SUBJECT: Engineering Review Comment
Mountain View Electric Association Inc. (MVEA)

Project Name: BOCES Campus – Approval Location for a Trade School
Project Number: U241

Description: Proposed development of a trade school located north of Judge Orr Rd. and east of Elbert Rd. in Township 12S, Range 64W, Section 35.

SHEET TITLE: PLOT PLAN

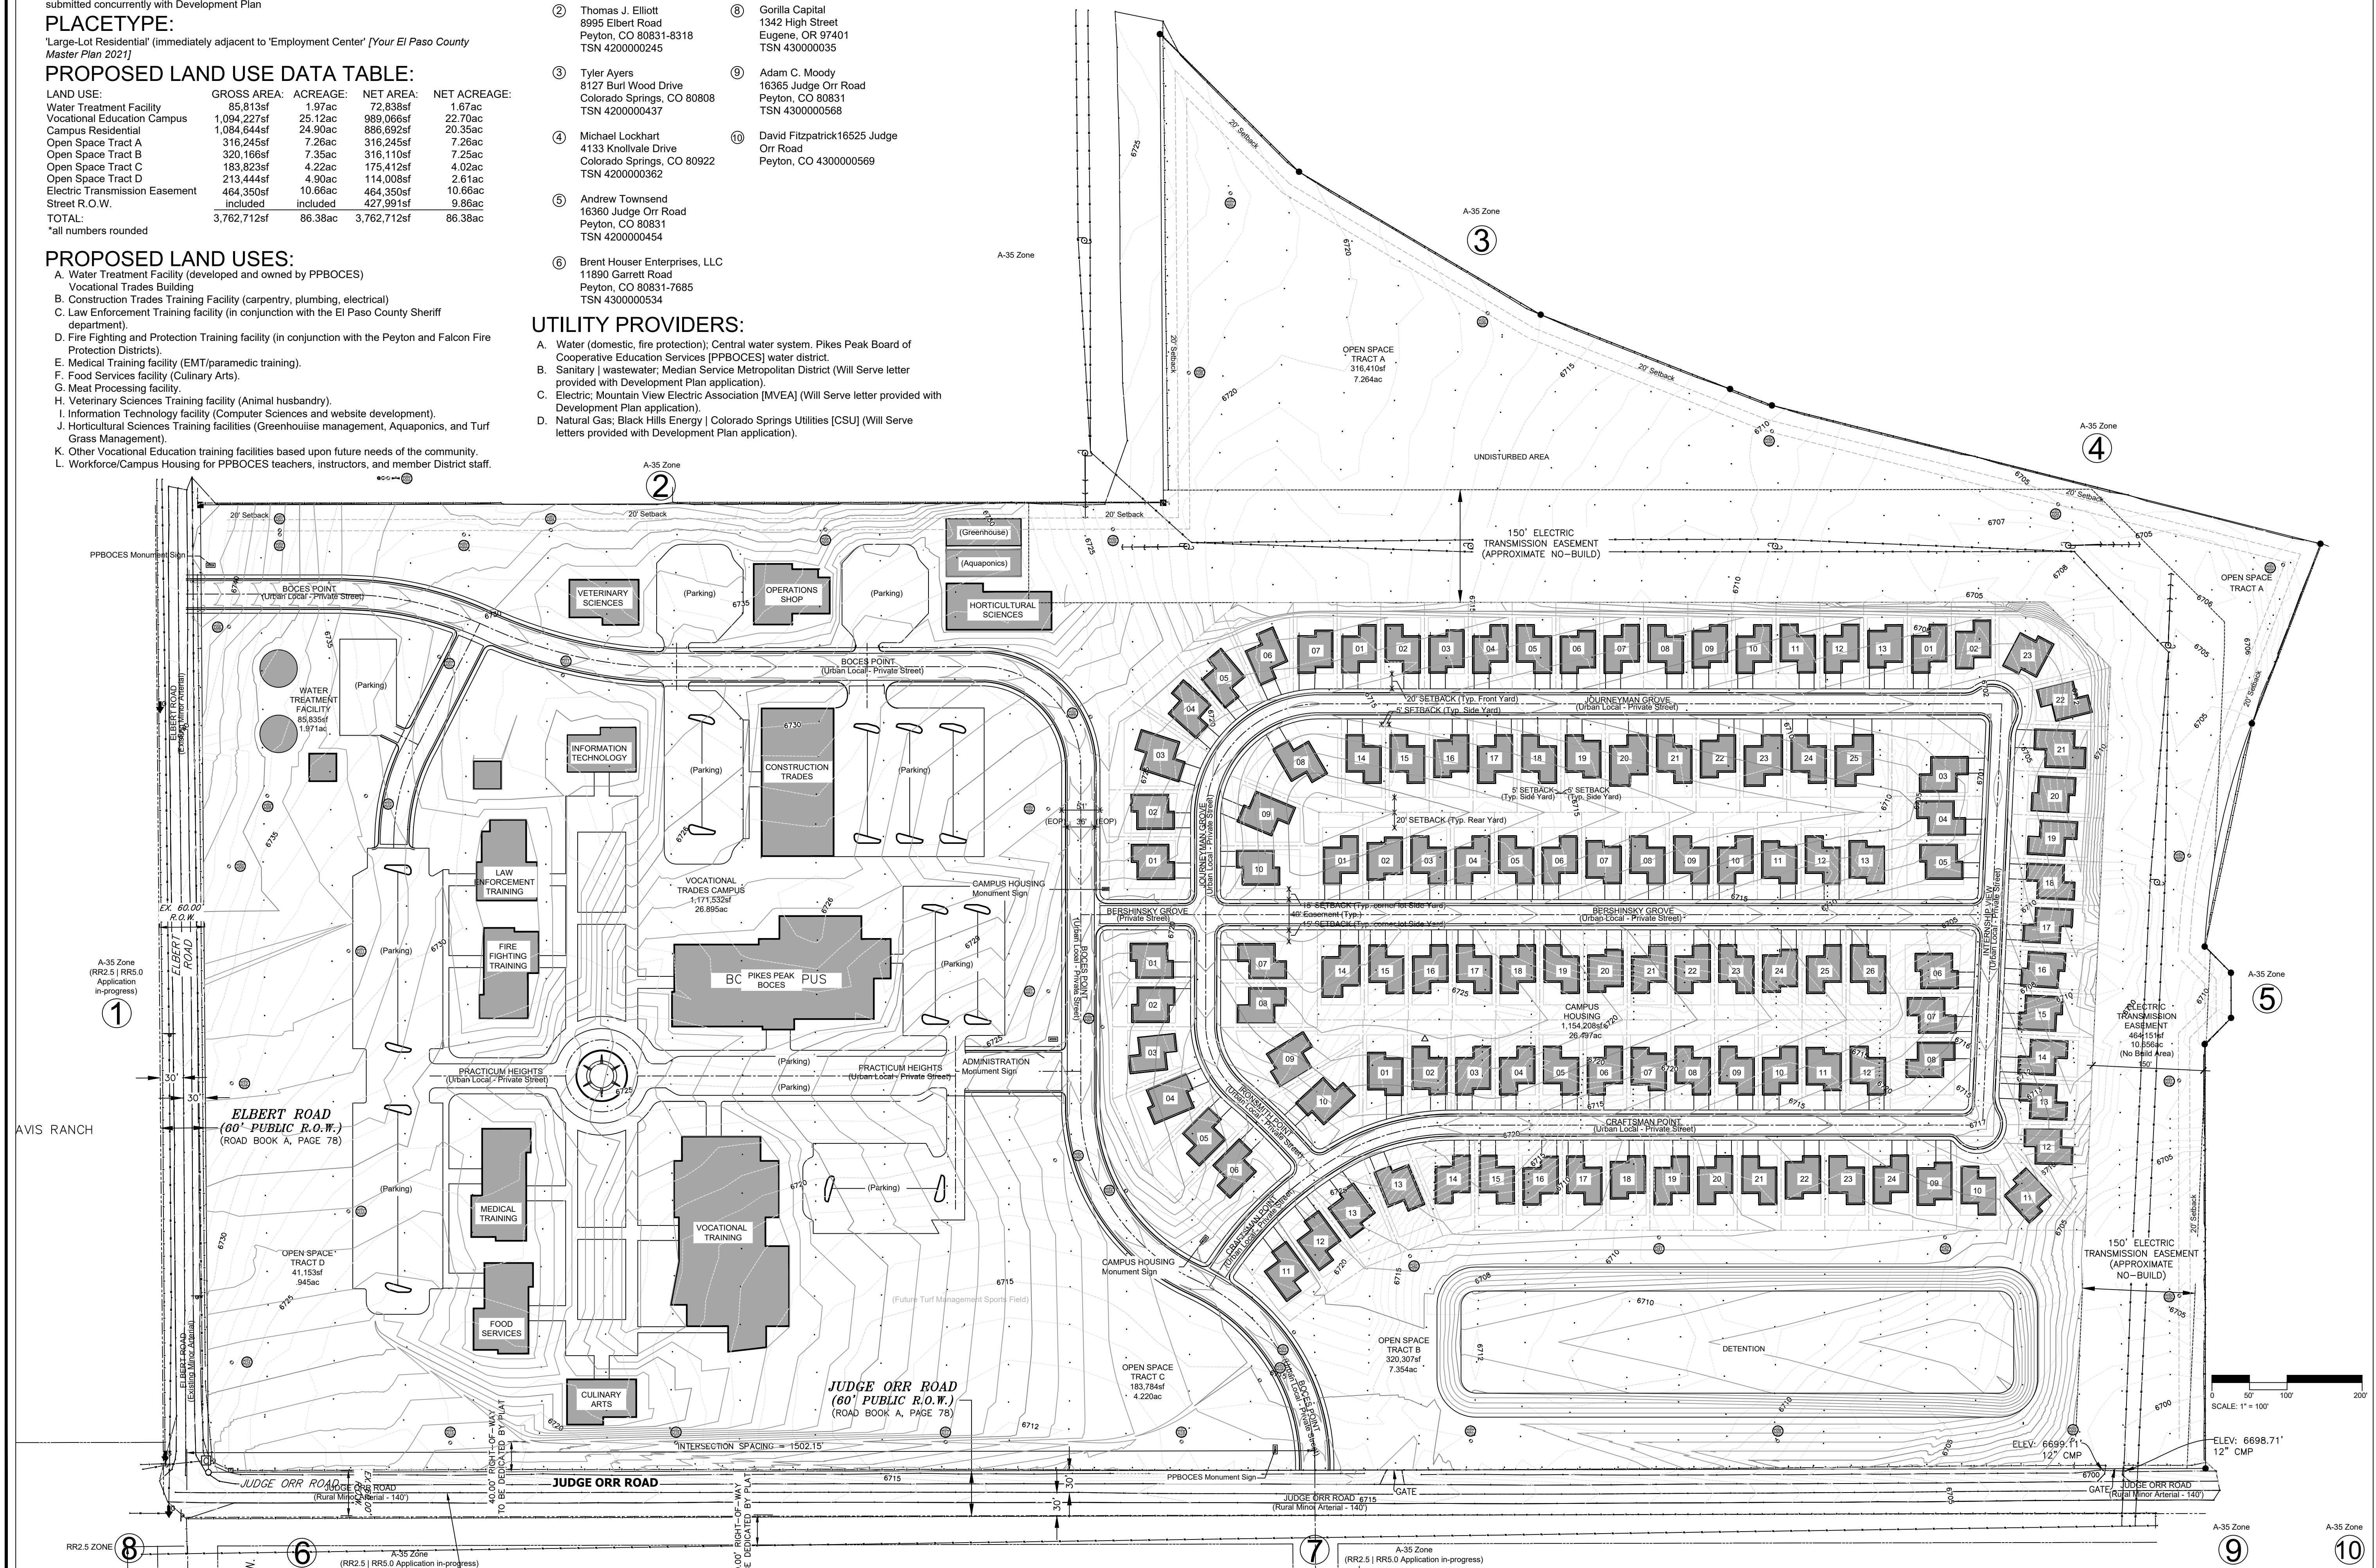
For the vocational trades campus, MVEA requests a 20' utility easement along both sides of the roads.

For the campus housing area, MVEA requests a ten (10) foot front lot utility easement, a five (5) foot side lot utility easement, and a seven (7) foot rear lot utility easement.

A twenty (20) foot exterior utility easement on the plat and all tracts include easements. MVEA also requests the platting of MVEA's existing facilities with easements on the plat.
